May 16, 2006

Re: Status of Improvement Permit Application #06-5-14691 – Forest Oaks 6454

SURVEY FOR: <b>PROPOSED PLOT PLAN - LOT - 56 FOREST OAKS S/D, PHASES ONE &amp; TWO</b>		<b>BENNETT SURVEYS, INC.</b> 1662 CLARK RD., LILLINGTON, N.C. 27546 (910) 893-5252	
TOWNSHIP ANDERSON CREEK	COUNTY HARNETT	20 0 40	SURVEYED BY: FIELD BOOK
STATE: NORTH CAROLINA	DATE: APRIL 17, 2006	DRAWN BY: DVP

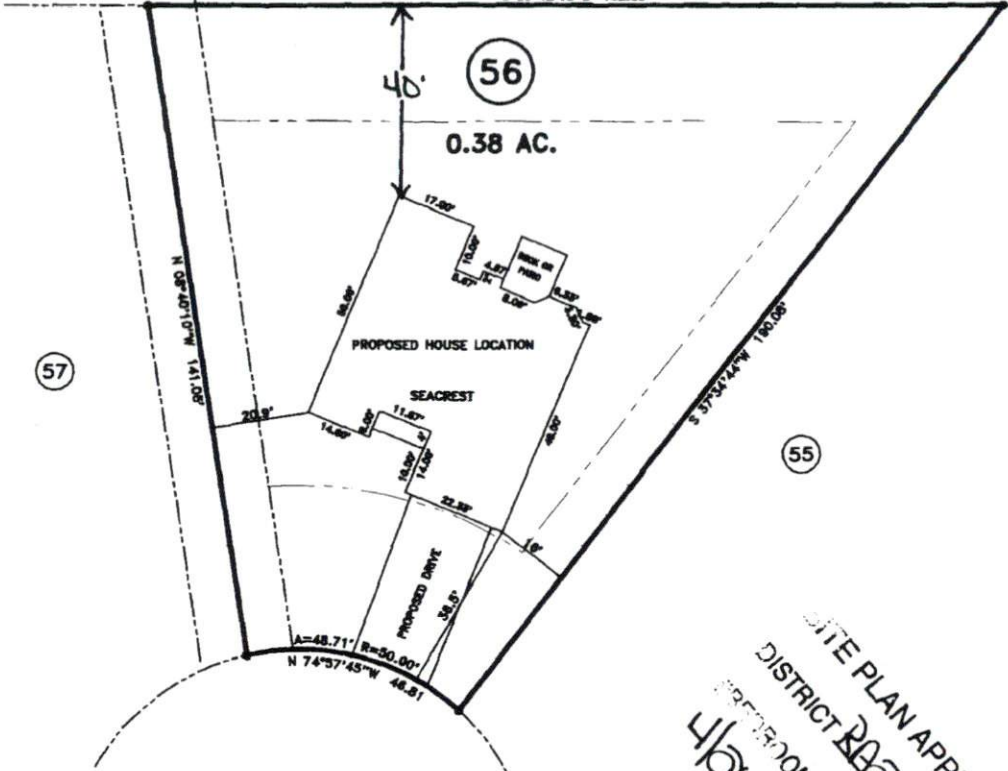
- 1. Property lines/corners not marked or labeled
- 2. House corners not marked or labeled
- 3. Directions not clear to property
- 4. Property needs brush or vegetation removed
- 5. Backhoe pits required
- 6. Other – The maximum house size for this lot is 3 bedrooms. Please make changes in house plans and resubmit to Central Permitting.
